Subject: BR/120/19/PL, BR/121/19/L, The Bandstand

Please find below the comments of our Conservation Officer:

A	MINOR AMENDMENT	16.04.19
REV	DESCRIPTION	DATE
PROJECT	BOGNOR REGIS BANDSTAND	
	THE ESPLANADE	
	BOGNOR REGIS	
	WEST SUSSEX	
DRAWING TITLE	PROPOSED ELEVATIONS, FLOOR PLAN AND ROOF PLAN

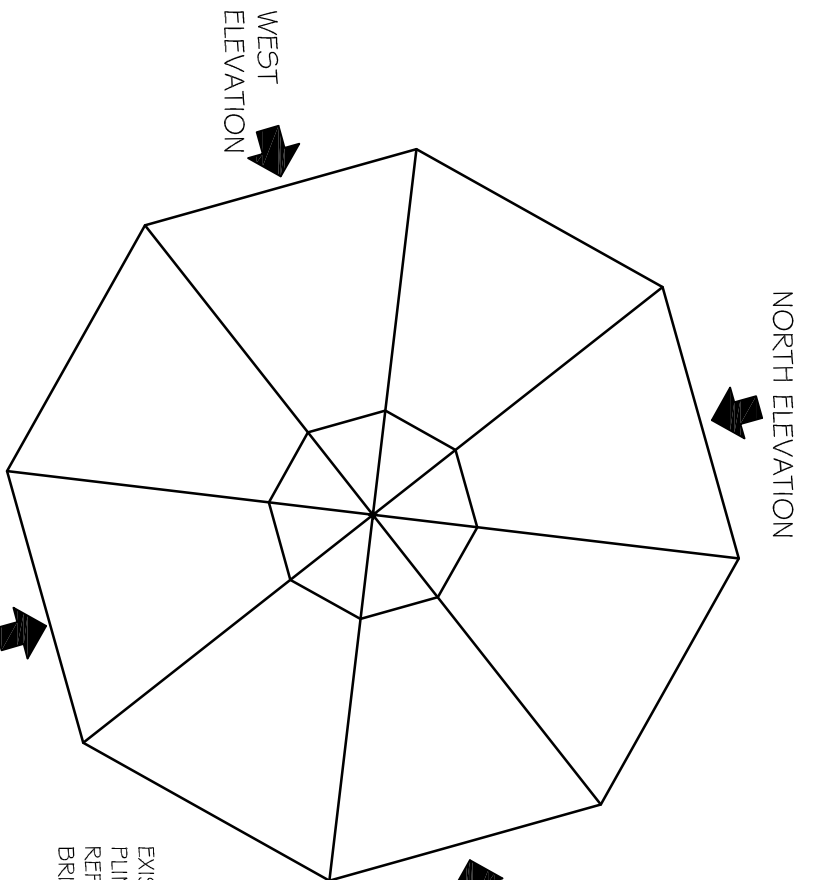
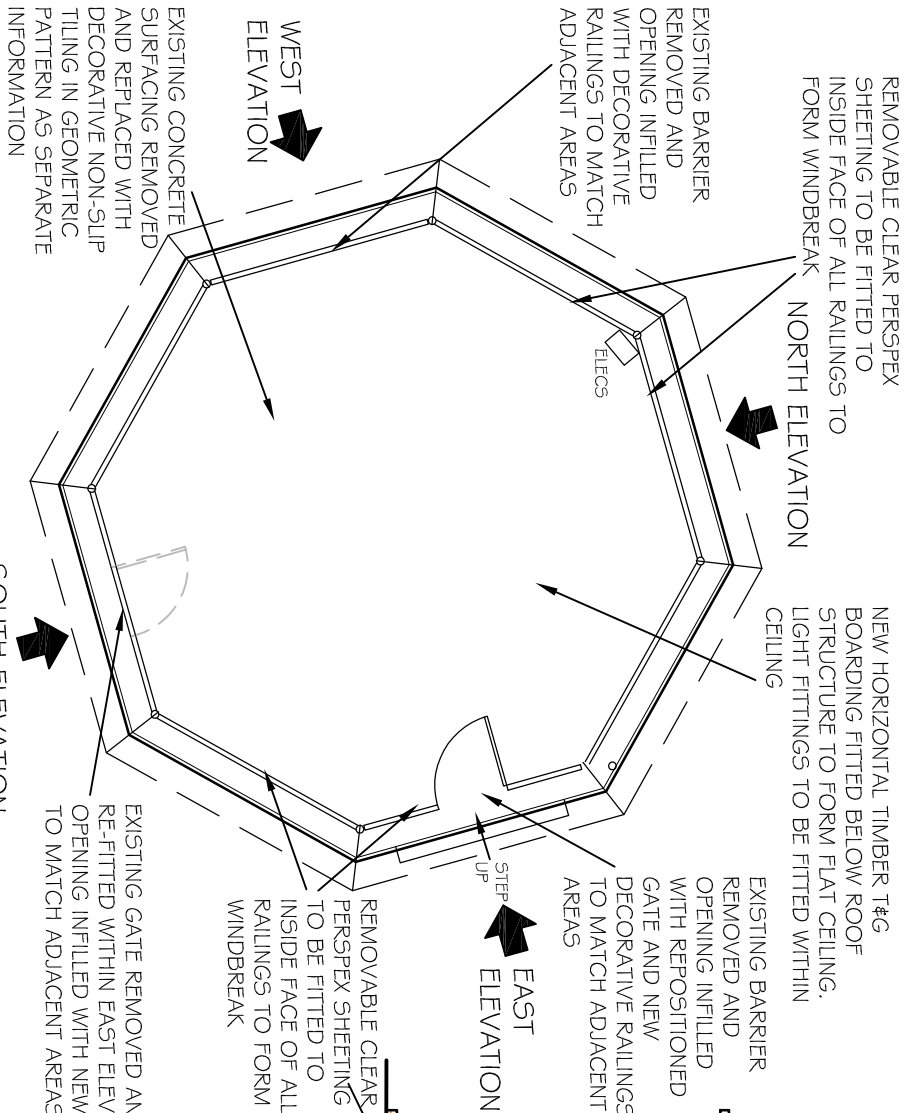
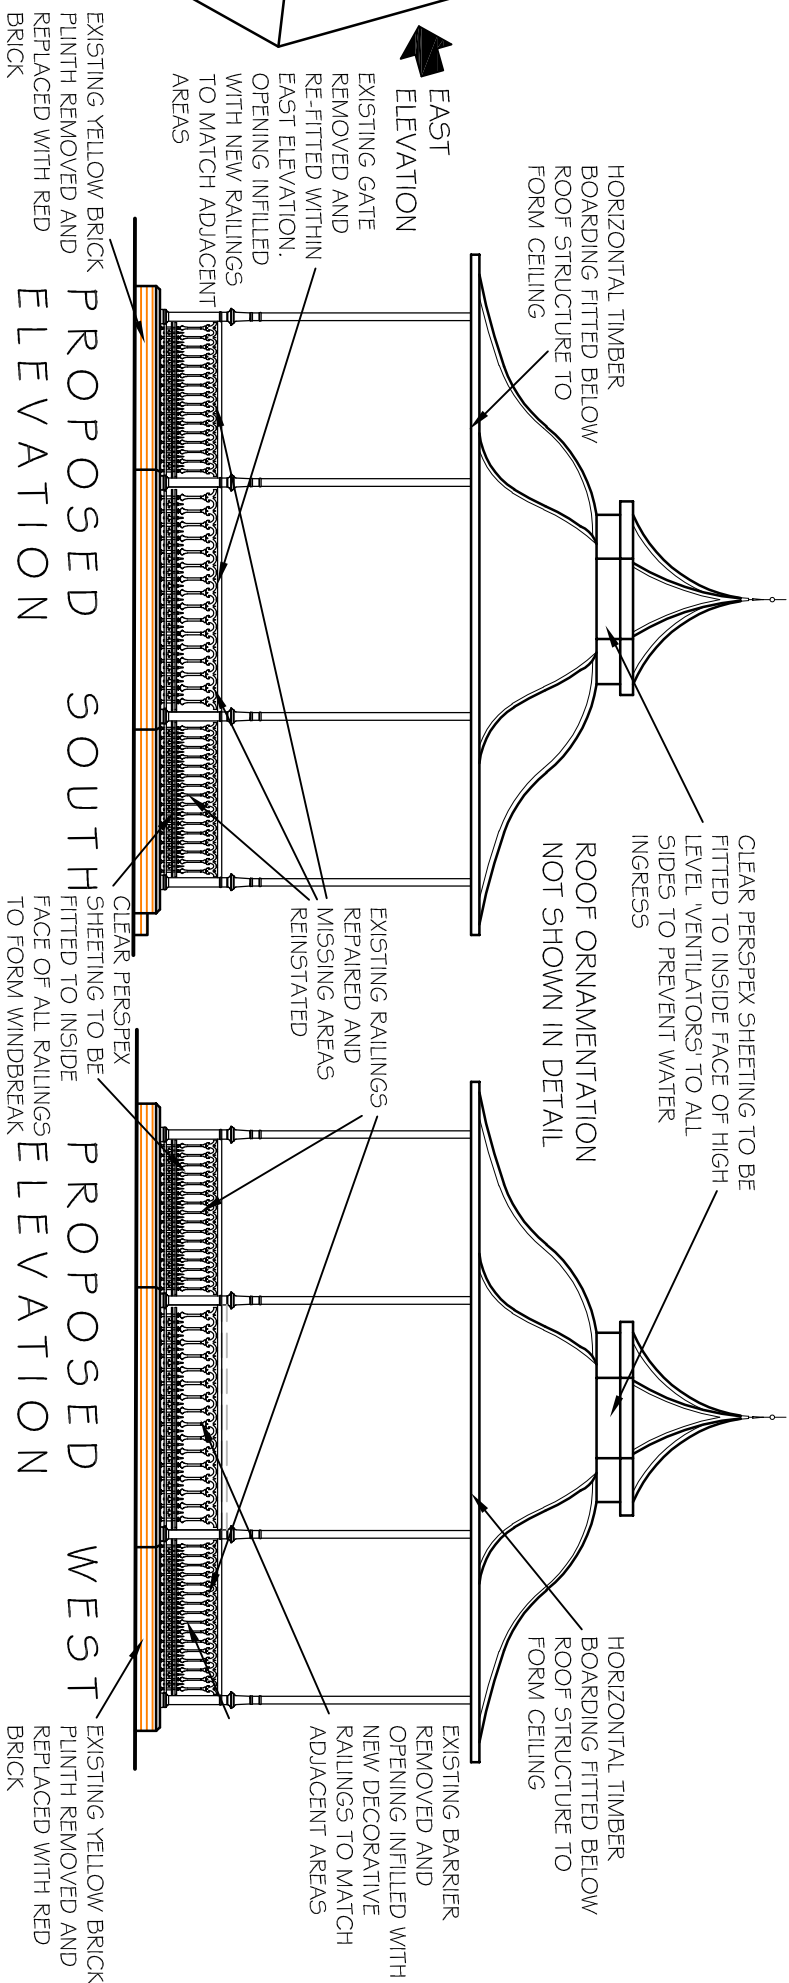
However, there are some issues which require clarification. It is not clear from reviewing the information why the location of the gate is to change.

Further, scant information has been provided regarding the proposed Perspex sheeting; how will it be fixed to the structure? Will it form a permanent element of the structure, or will it be used on a temporary basis (and removed when not required)? Further, what size will the panels be? What would the quality of the materials used be? At present, such an issue is considered to be problematic.

- **Relocation of access gate.** The Bandstand has previously been disassembled and re-assembled and is not in its original location. There is no particular historic or architectural significance related to the current positioning of the access gate except that it faces directly onto the seafront. The balustrading and handrail (and associated access gate) are relatively interchangeable between the main structural support posts as the structure is a regular, symmetrical shape. The relocation of the gate will position it where there is currently an access step, which would seem an entirely logical location as this position would enable easy access and egress without disturbing the main thoroughfare along the promenade.

- **Perspex sheeting.** I can confirm the Perspex sheeting that was proposed to the metal railings has now been omitted from the proposals.
The proposed Perspex sheeting at high level will be fitted on the inside face of the decorative ironwork and is required to prevent rainwater penetration into the roof structure and onto the proposed ceiling. This Perspex sheeting will be clear and would barely be visible from ground level. It will be fixed in a manner to enable removal on a future occasion to ensure the work is entirely reversible.

REV	DESCRIPTION	DATE
PROJECT BOGNOR REGIS BANDSTAND THE ESPLANADE BOGNOR REGIS WEST SUSSEX		
DRAWING TITLE REFLECTED CEILING PLAN AND LIGHTING PLAN

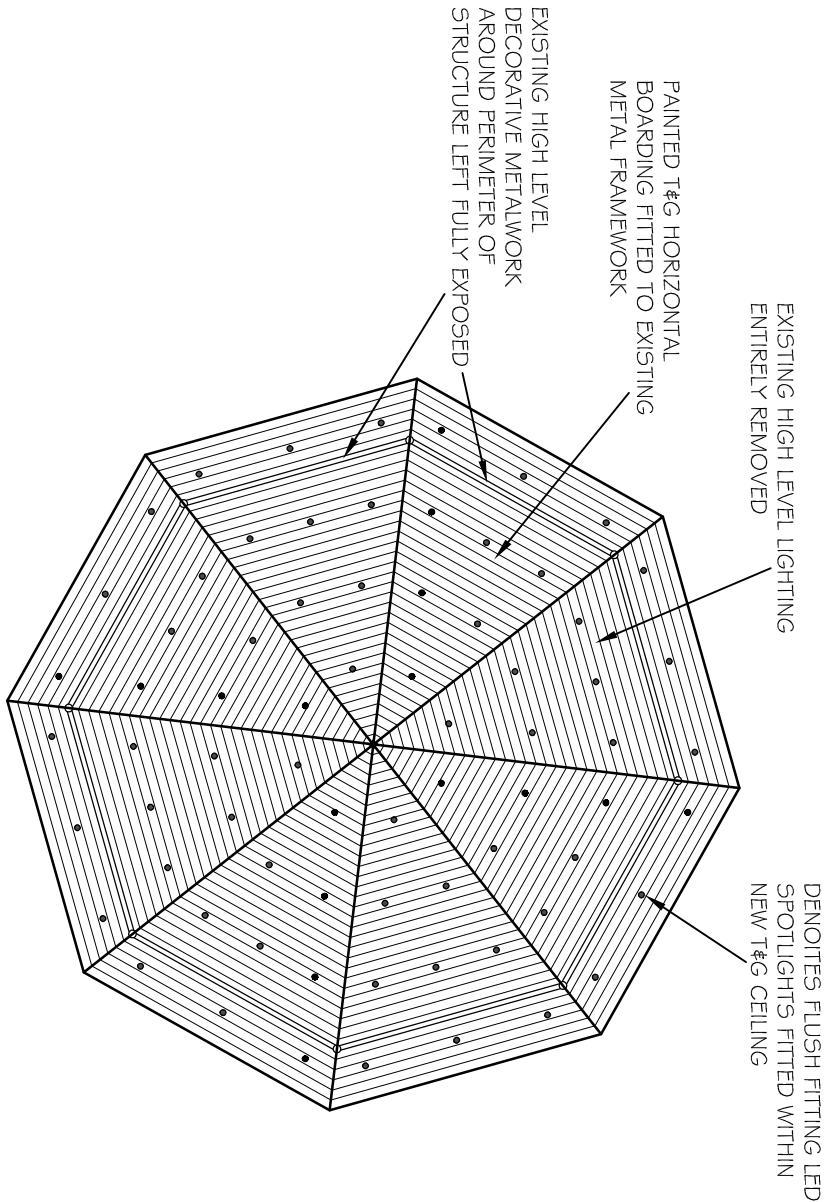
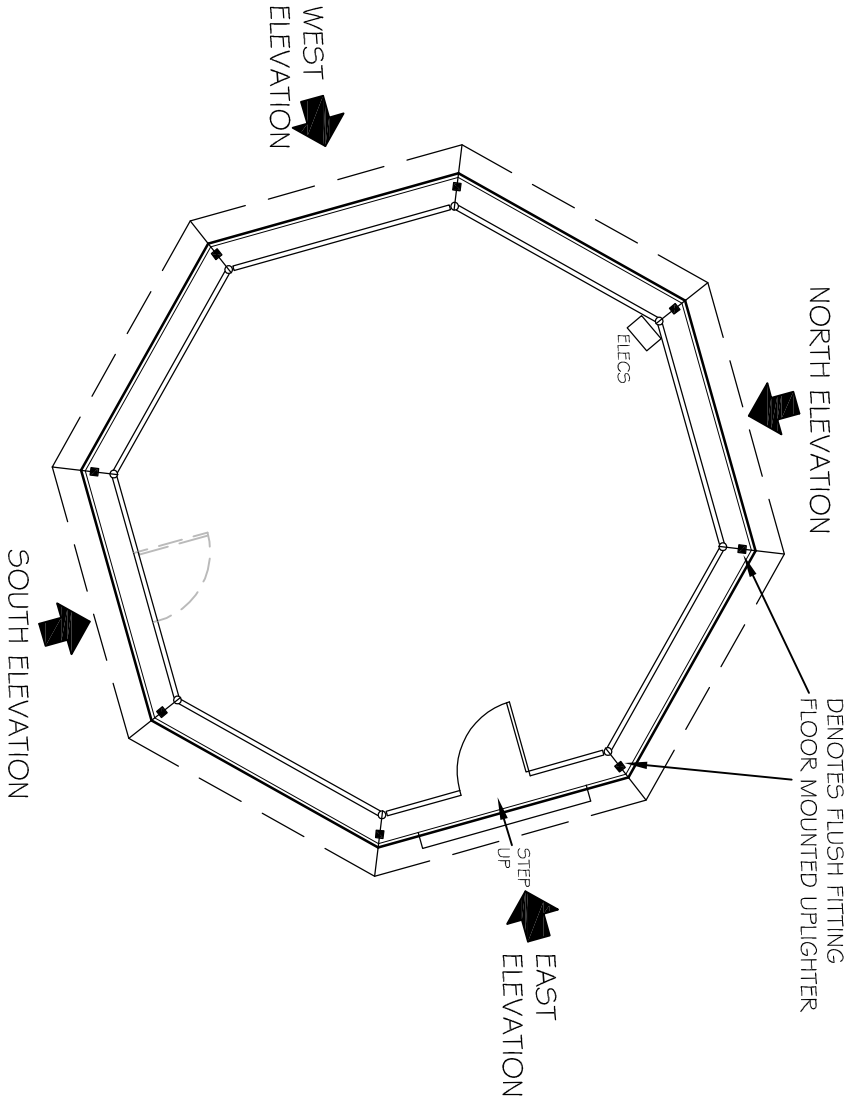
Also how will the horizontal timber boarding to be fitted below the roof structure to form a ceiling be treated?

- **Timber ceiling boarding.** The new timber boarding will be fitted to existing horizontal metal framework and would have a painted finish.
- **Materials.** We accept that a suitably worded condition will need to be applied to agree the details of the new bricks and other items.
